From: Brian Holland
Sent: 15 October 2010 12:24
To: Planning.Responses
Subject: RE: Planning Consultation on: P/103/10/DOC at Sefter Farm

Engineer's Drainage Comments:

APPLICATION P/103/10/DOC
NO:

Description of Works: Application for approval of details reserved by conditions 2 & 3 of planning permission P/97/09

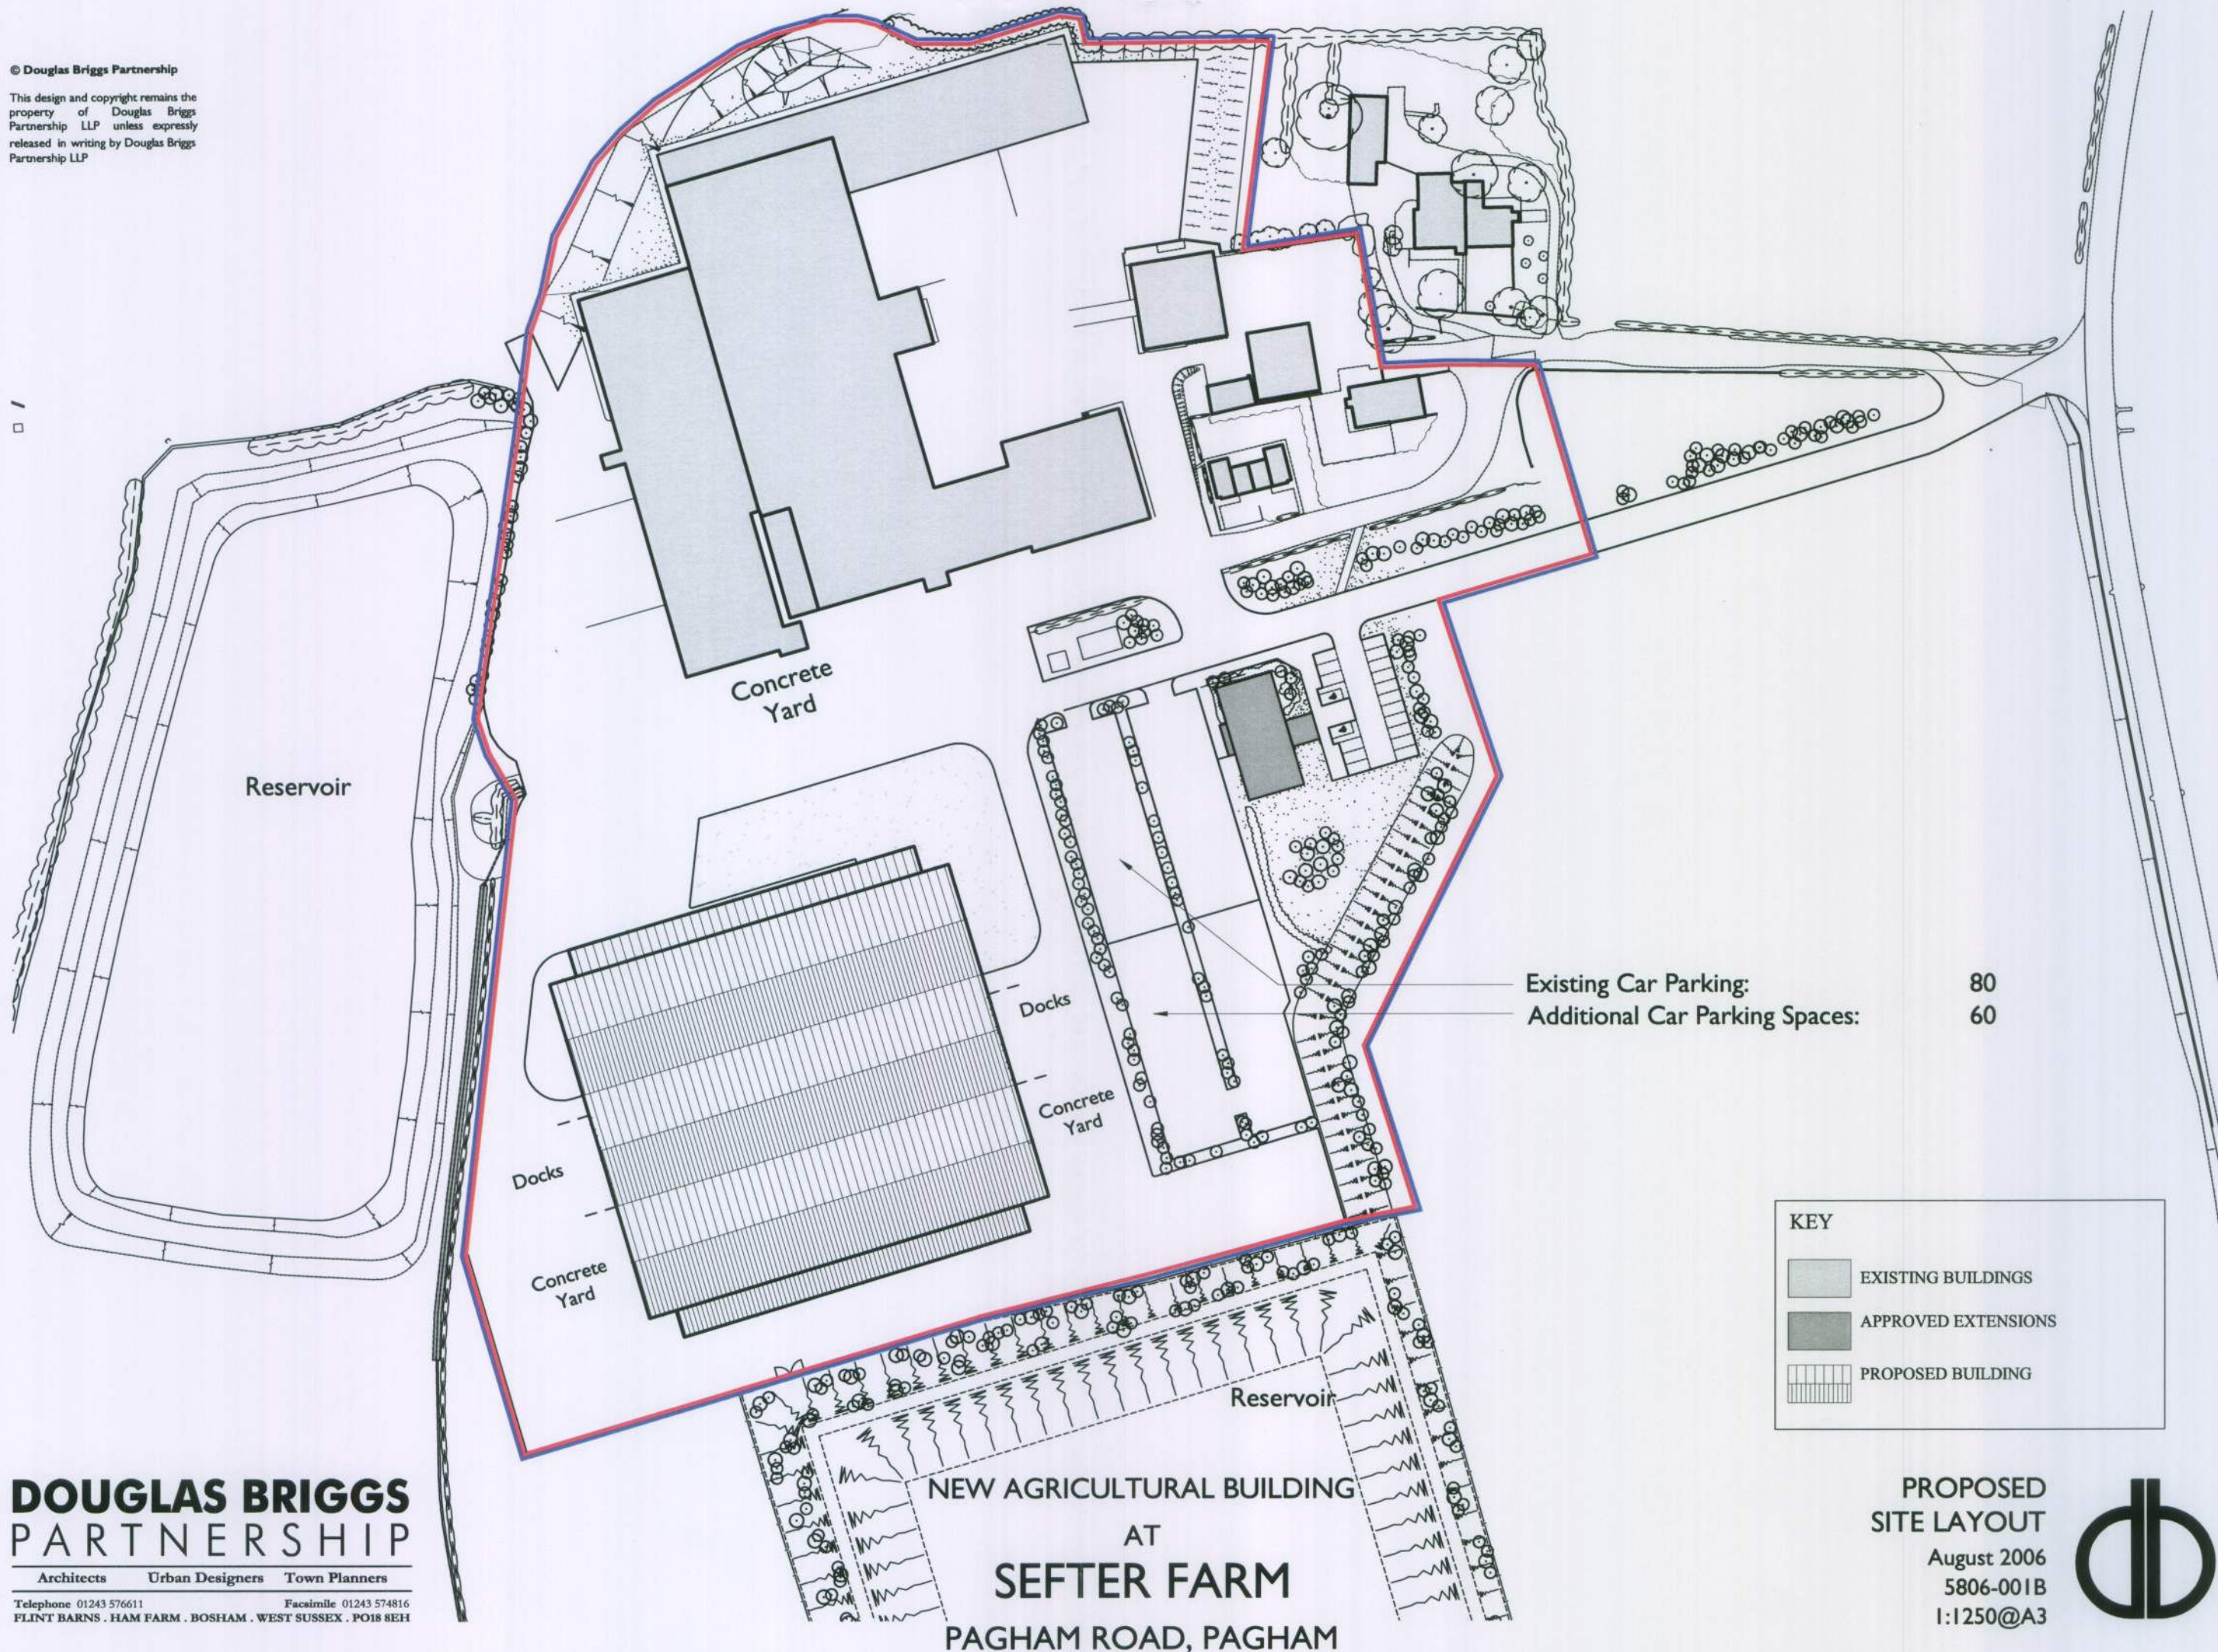
The drawing provided has minimal details of the proposed drainage system. It is entitled Proposed Landscape Plans and contains details of those features. The majority of the area surrounding the building is shown as concrete yard / concrete access and apparently shows impermeable areas of circa 3350 square metres, as compared to the 4000 square metres recommended in the HR Report. There are no details provided of the proposed impermeable areas. The drainage of the hardstanding area on the drawing to the right (east?) of the building indicates 'connection to ditch' but gives no details of which ditch and how it is connected, there are no details shown of how the drainage of the hardstanding to the left (west?) of the building is dealt with. The HR report indicates that all impermeable areas will be drained through the permeable areas, they are not. The outflow from the permeable storage area is via orifices for both 1 year and 100 year flows - no such detail is shown. The building drainage to the left (west?) of the building states 'connection to reservoir' but shows no details of the actual proposals.

Hence I consider there is insufficient details and information provided and I therefore cannot recommend discharge of Condition 3 regarding the proposed surface water drainage.
